From: Sue Howell
Sent: 07 January 2020 15:07
To: Planning.Responses <Planning.Responses@arun.gov.uk>
Cc: Anita Gardner <Anita.Gardner@arun.gov.uk>
Subject: RE: Planning Consultation on: A/166/19/RES

Comment from Greenspace

APPLICATION NO: A/166/19/RES

Site Address: The Laurels Dappers Lane Angmering BN16 4EN

Client ECE Planning			
Project Title and Location The Laurels Dapper's Lane, Angmering, West Sussex			
Drawing Title Detailed Planting Plan 2 of 3 Infrastructure Planting			
Scale 1:250@A1	Drawn EZ	Approved TT	Date 25.10.2019
Drawing No LLD1834-LAN-DWG-202			Revision 01

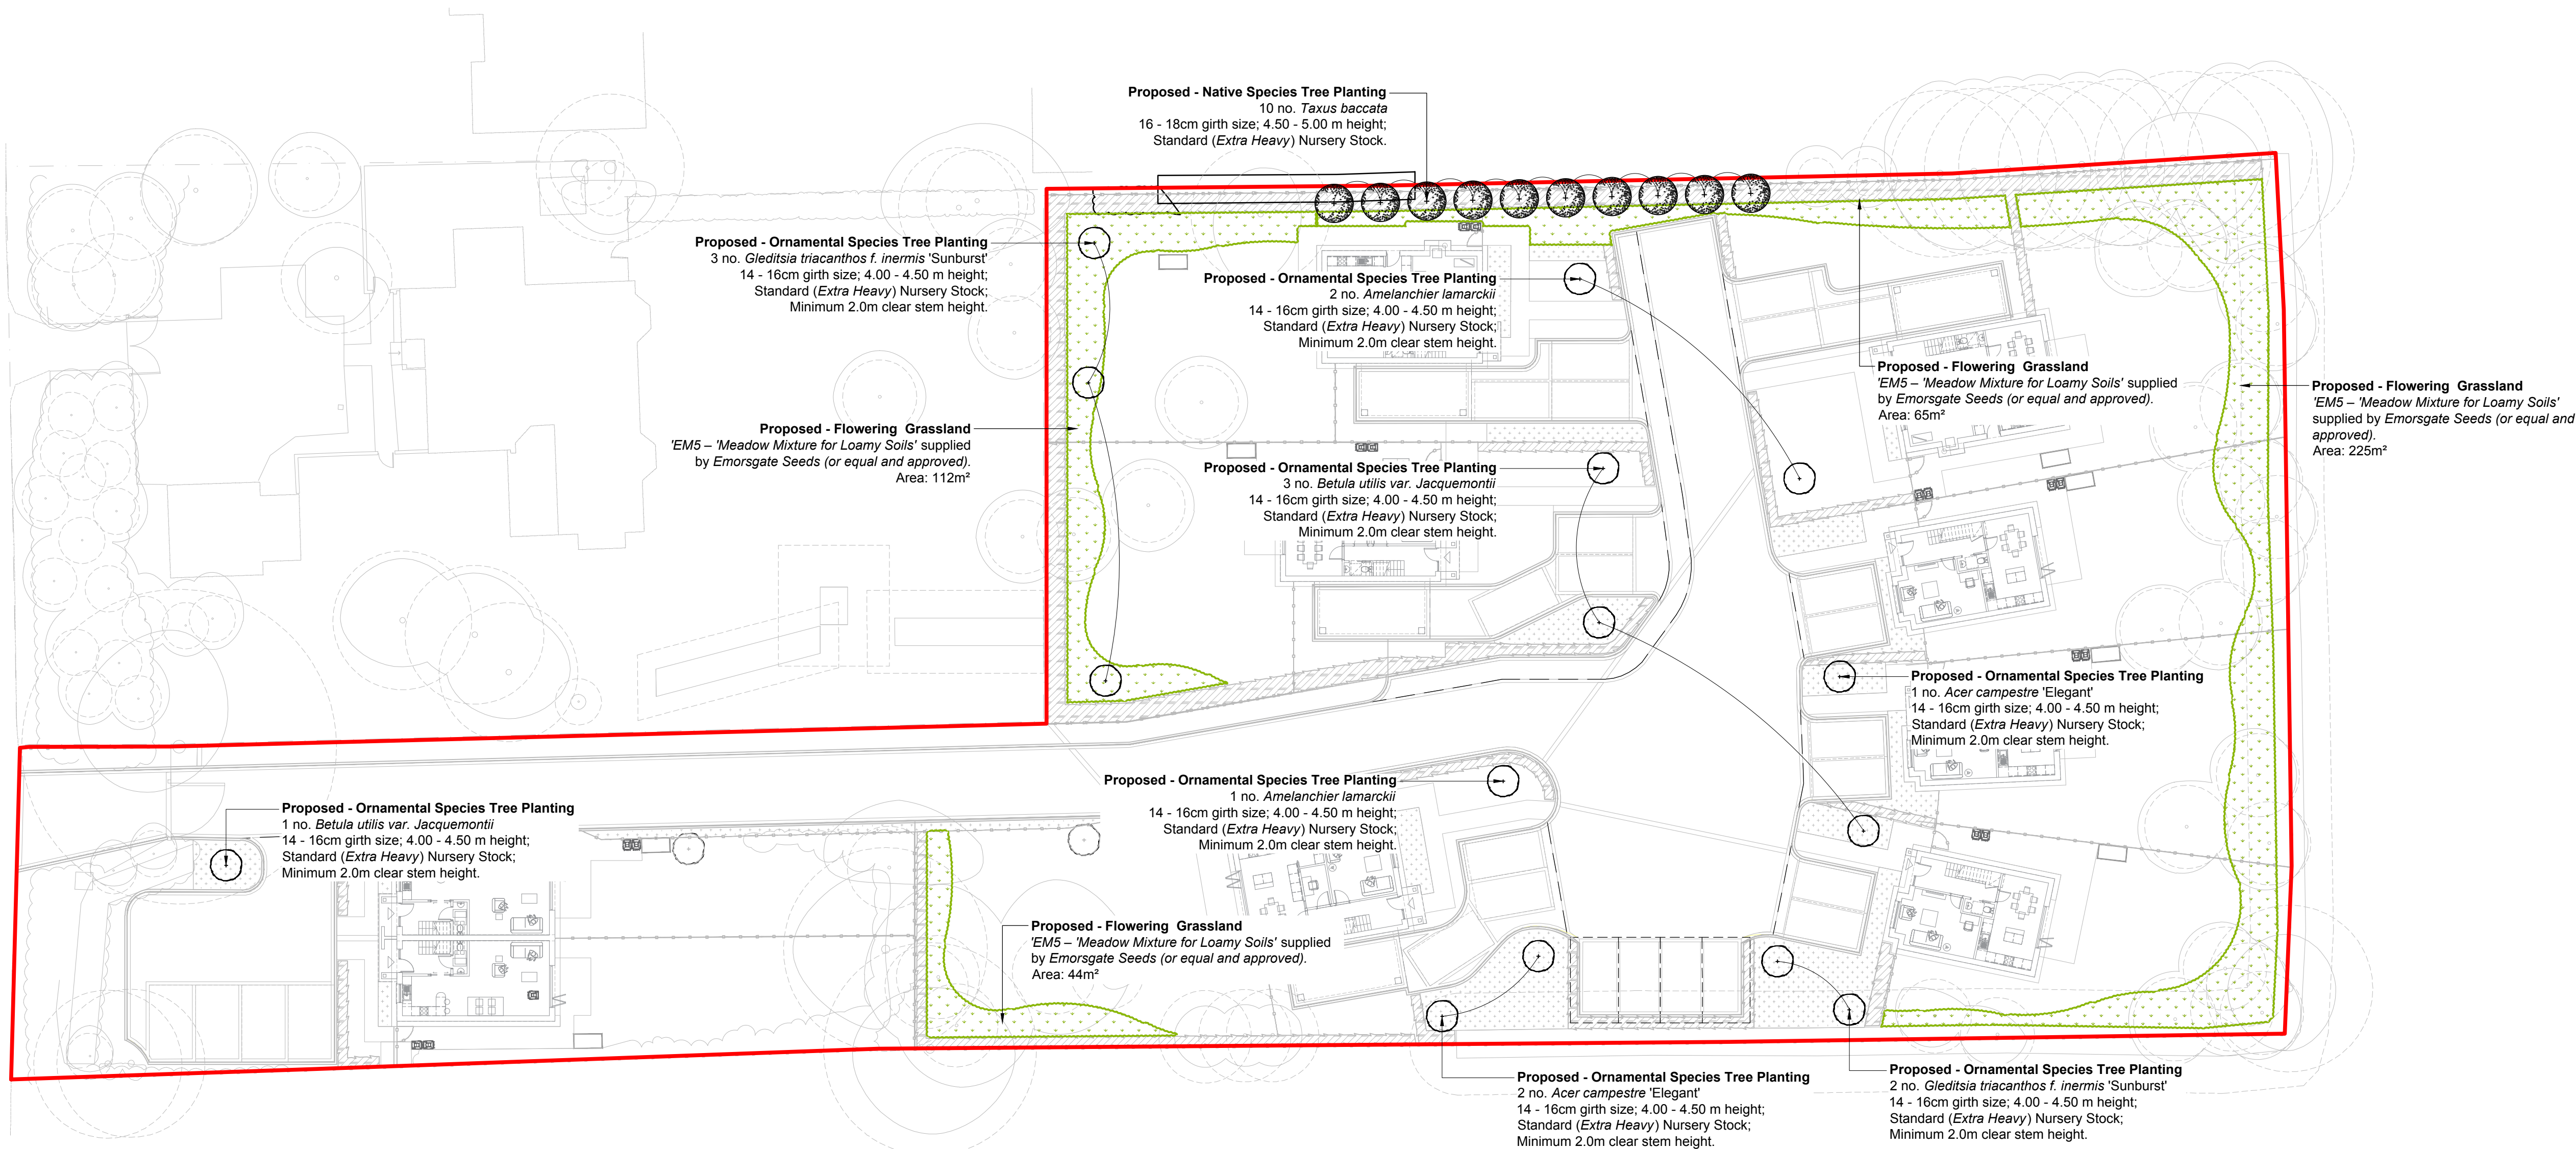
The information contained in Soft Landscape sketch plan 200 Rev 01 and further in 'Detailed planting plans 1-3 201, 202, 203 Rev's 01 proposes a well thought out and comprehensive scheme with trees, hedges, native planting, shrubs, grasses and buffer edge. The proposed scheme contains a good mix which will provide softening/screening improving the setting, more so over time as the planting matures. The scheme is adequately detailed with quantities and size at time of planting, providing trees which will add instant impact a species mix across the proposals both deciduous and evergreen which will add good biodiversity benefit to the site.
